From: Jonathan Best <Jonathan.Best@arun.gov.uk>
Sent: 24 January 2025 11:40
To: Planning.Responses <Planning.Responses@arun.gov.uk>
Cc: Harry Chalk <Harry.Chalk@arun.gov.uk>
Subject: R/239/24/PL

Condair Building Artex Avenue Rustington BN16 3LN.

I have reviewed this application with regards to ecology and Biodiversity Net Gain.

Site Proposed Habitat Plan
Condair, Rustington
GS334.Condair.SPHP.v1

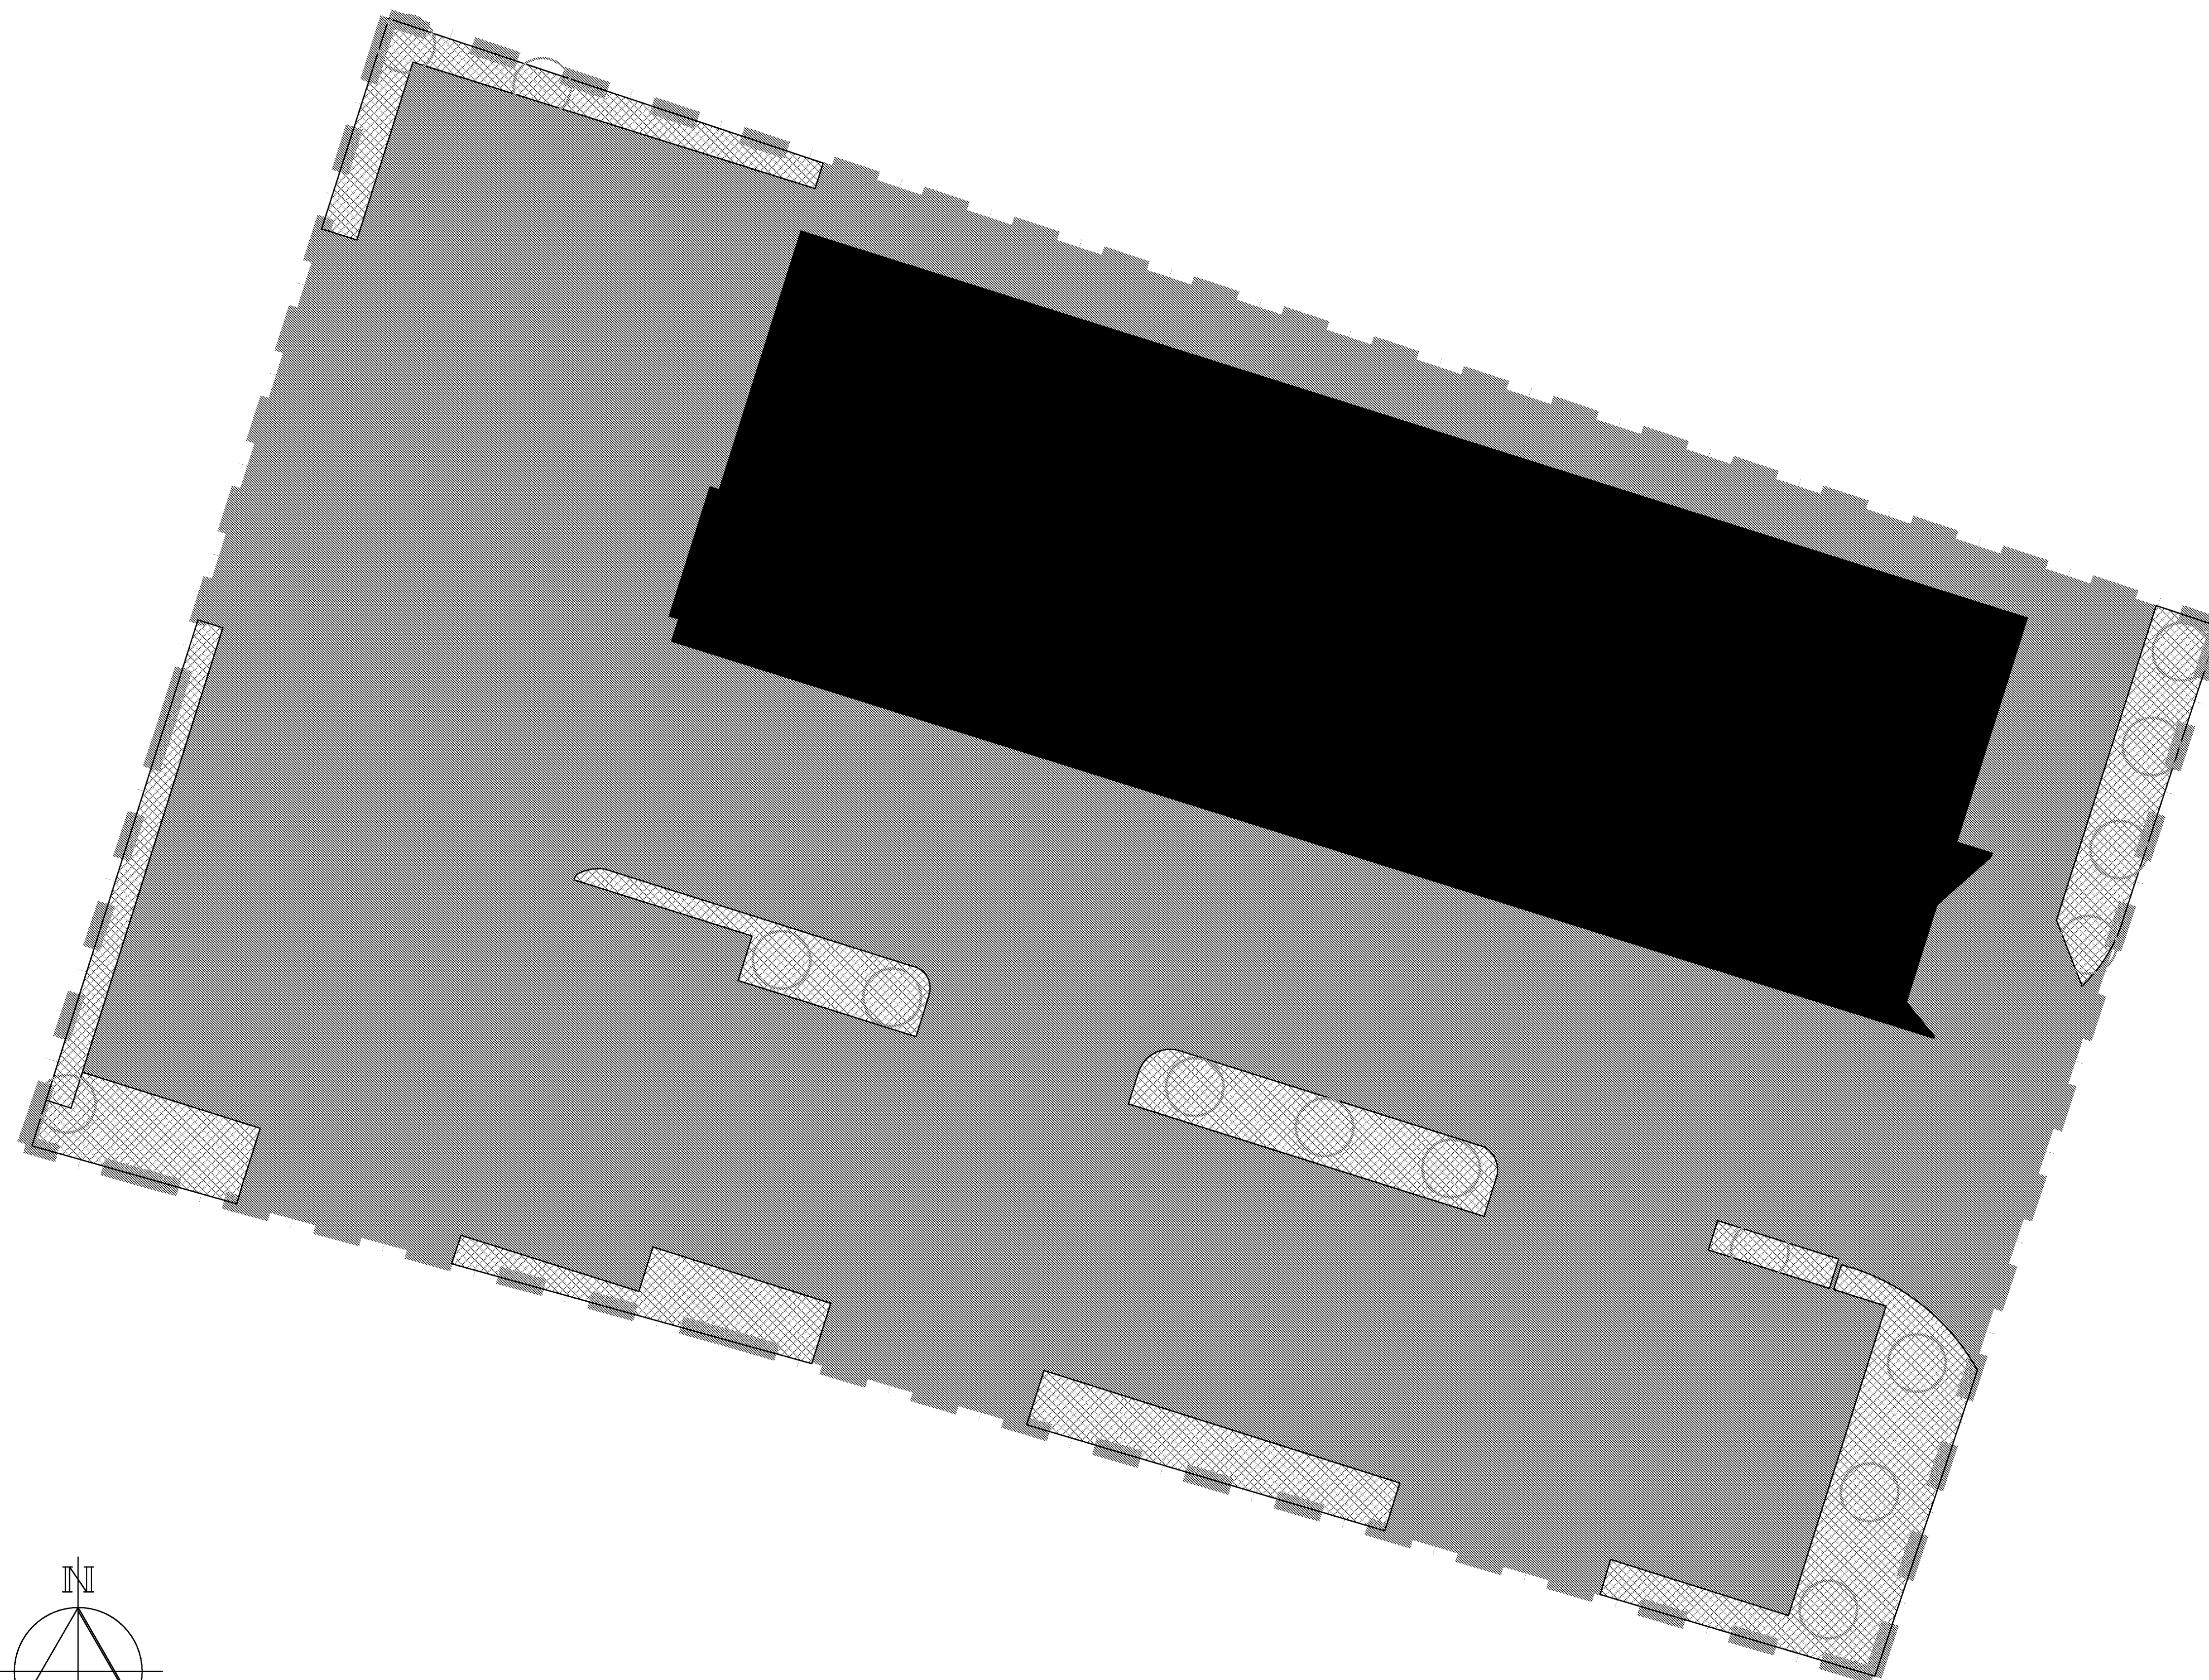
The BNG assessment and metric shows an increase of 2,517.17% in habitat units. This exceeds the mandatory 10% required. This is achieved through creation of shrub planting and planting 16 urban trees.

I advise installing 3 integral swift bricks.

BNG1
ECOBNG2 – 3 swift bricks, 2 bee bricks/bug hotels and maintenance of the shrubs and trees.
